Online Comment

Application H09-1006-19
Location Holbeach Cemetery Chapels Holbeach Cemetery Park Road PE32 7EE
Proposal Change of use from Class D1 Religious to D1 Educational and Community, including creation of disabled parking and turning bay, diversion of path around building, external alterations and trenching for drainage, water and electrical services

Name Ian Marshman
Address Lincolnshire County Council Lancaster House 36 Orchard Street LN1 1XX

Date Submitted 15-11-19
For/Against Comments

Proposed site plan
Scale: Drawing By: Date:

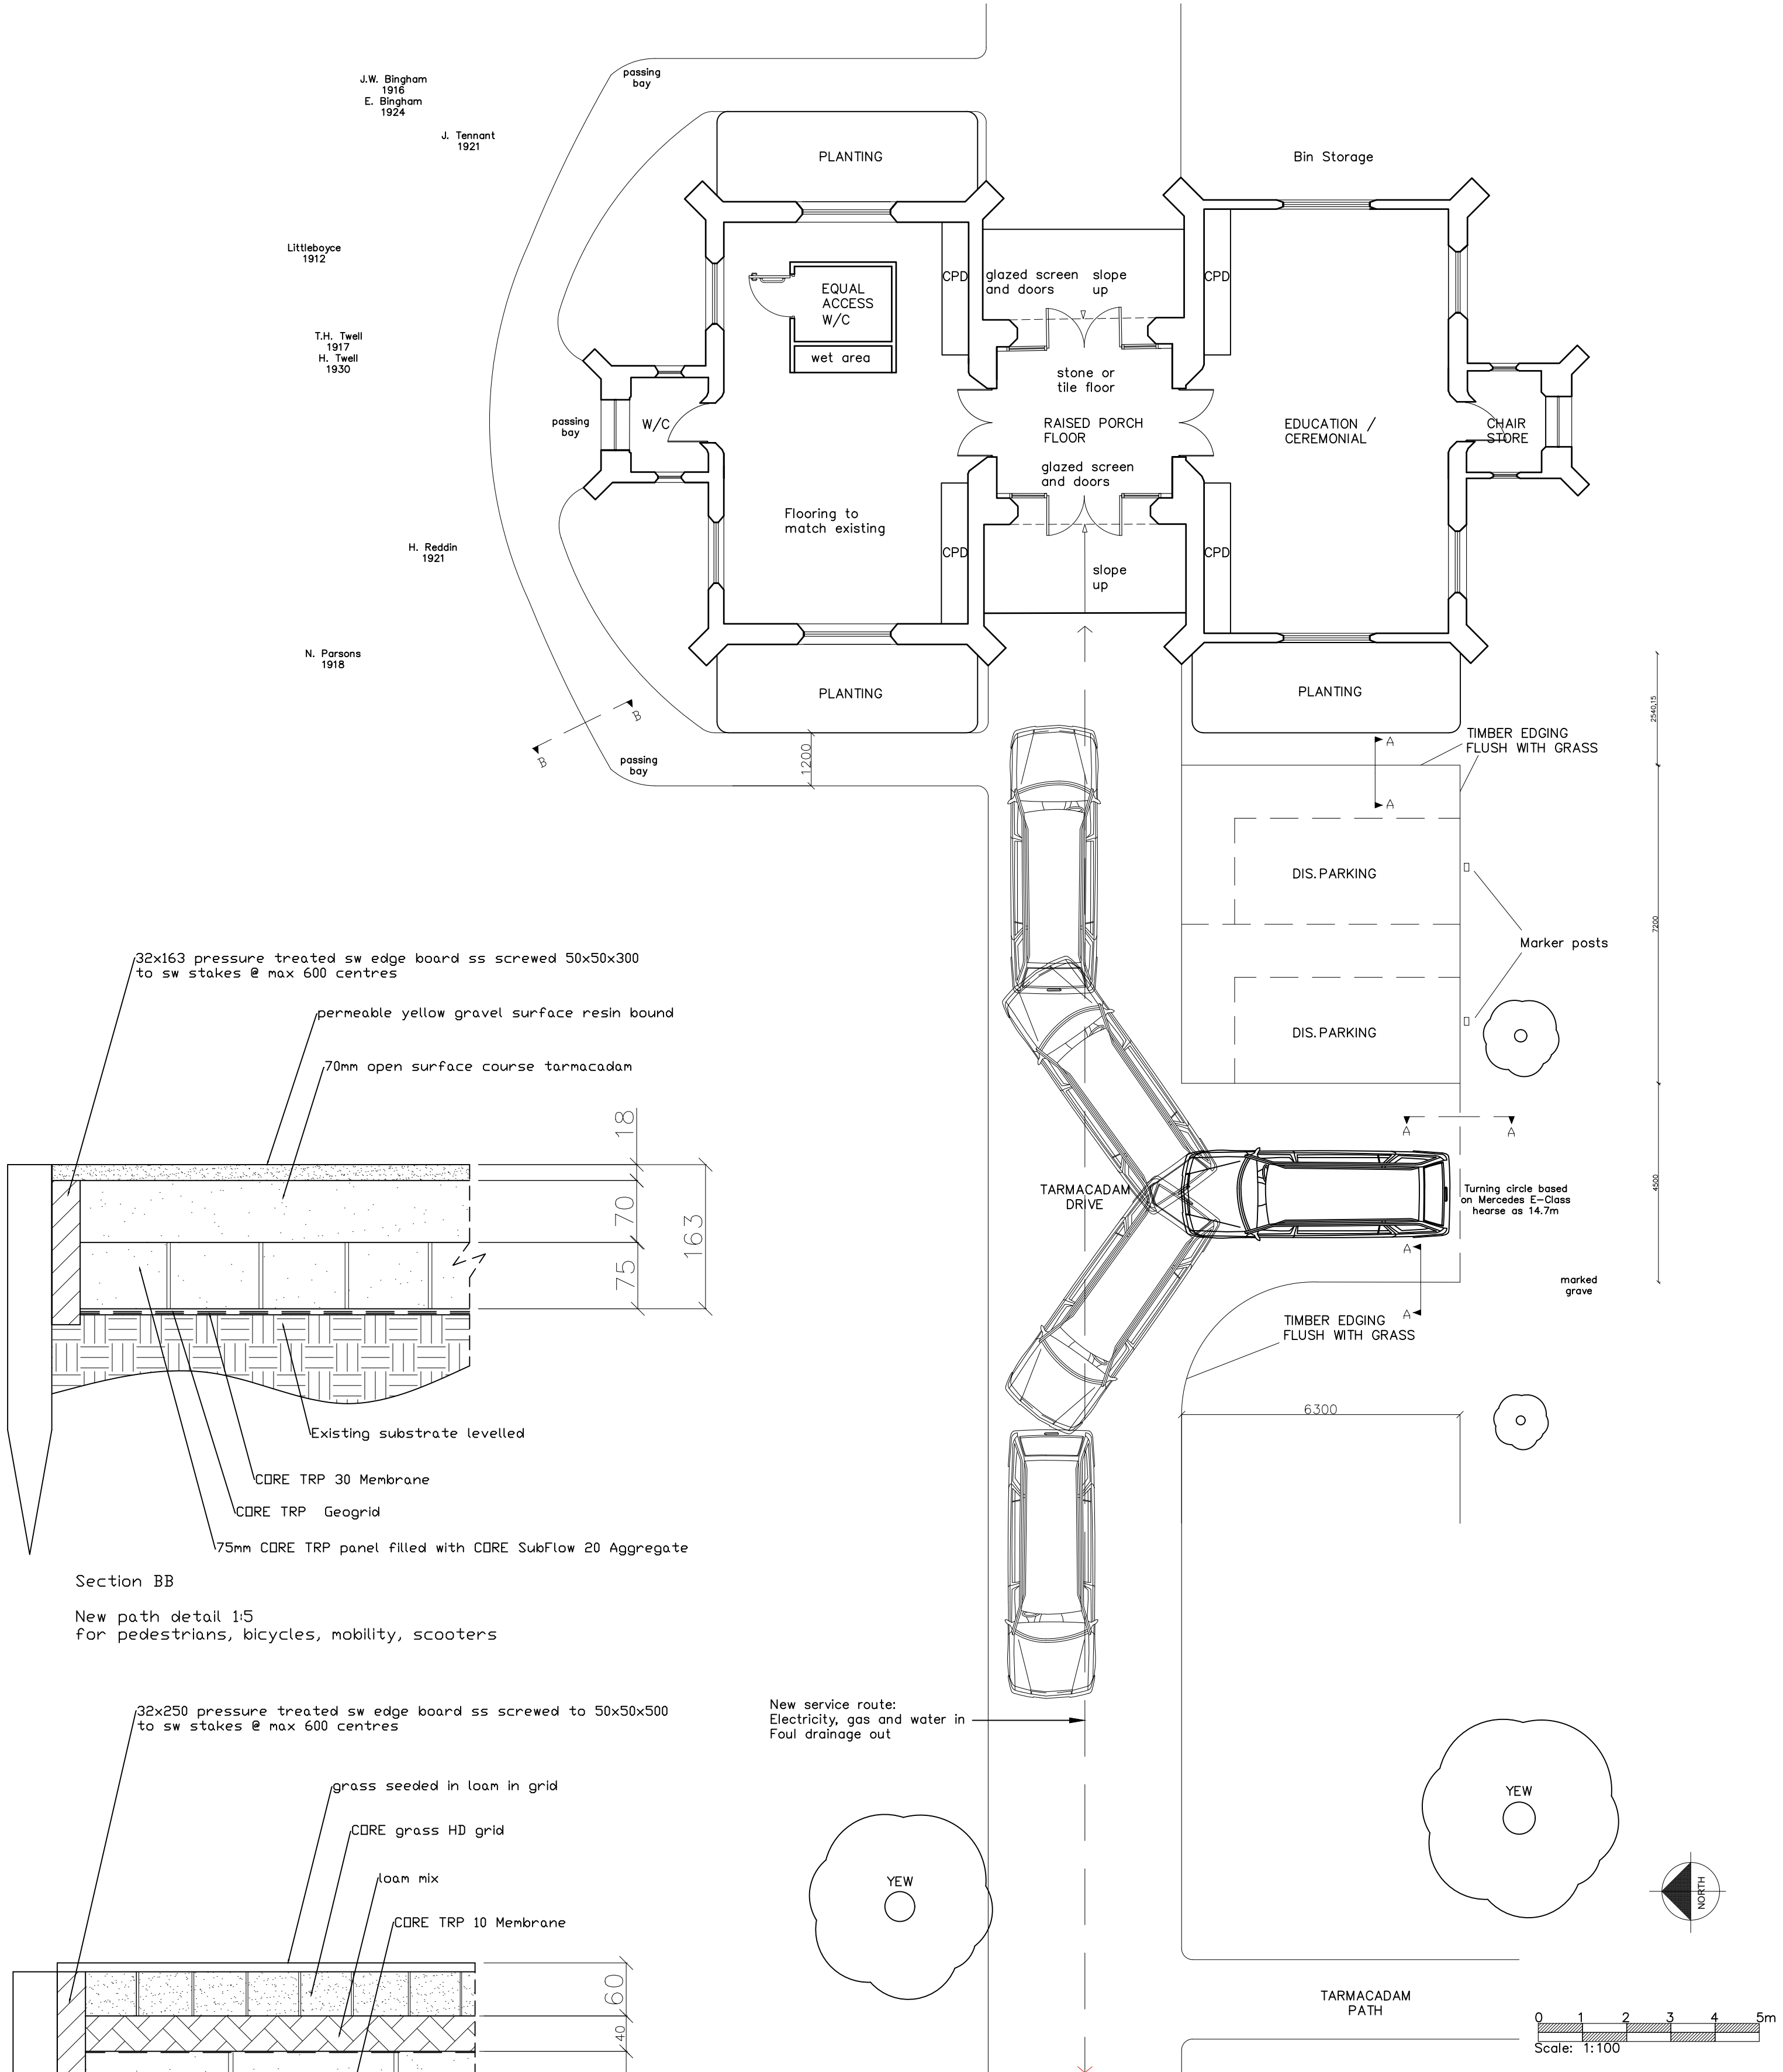
We would not recommend any archaeological involvement in the groundworks proposed, on the basis that there are no known graves in the areas affected and the work will only disturb the near surface, which in a modern cemetery of this kind means it is unlikely that there would be an impact on any human remains.

If during the course of groundworks human remains or unexpected archaeology is encountered, the developer should contact this office immediately so that we can ensure that they are recorded.
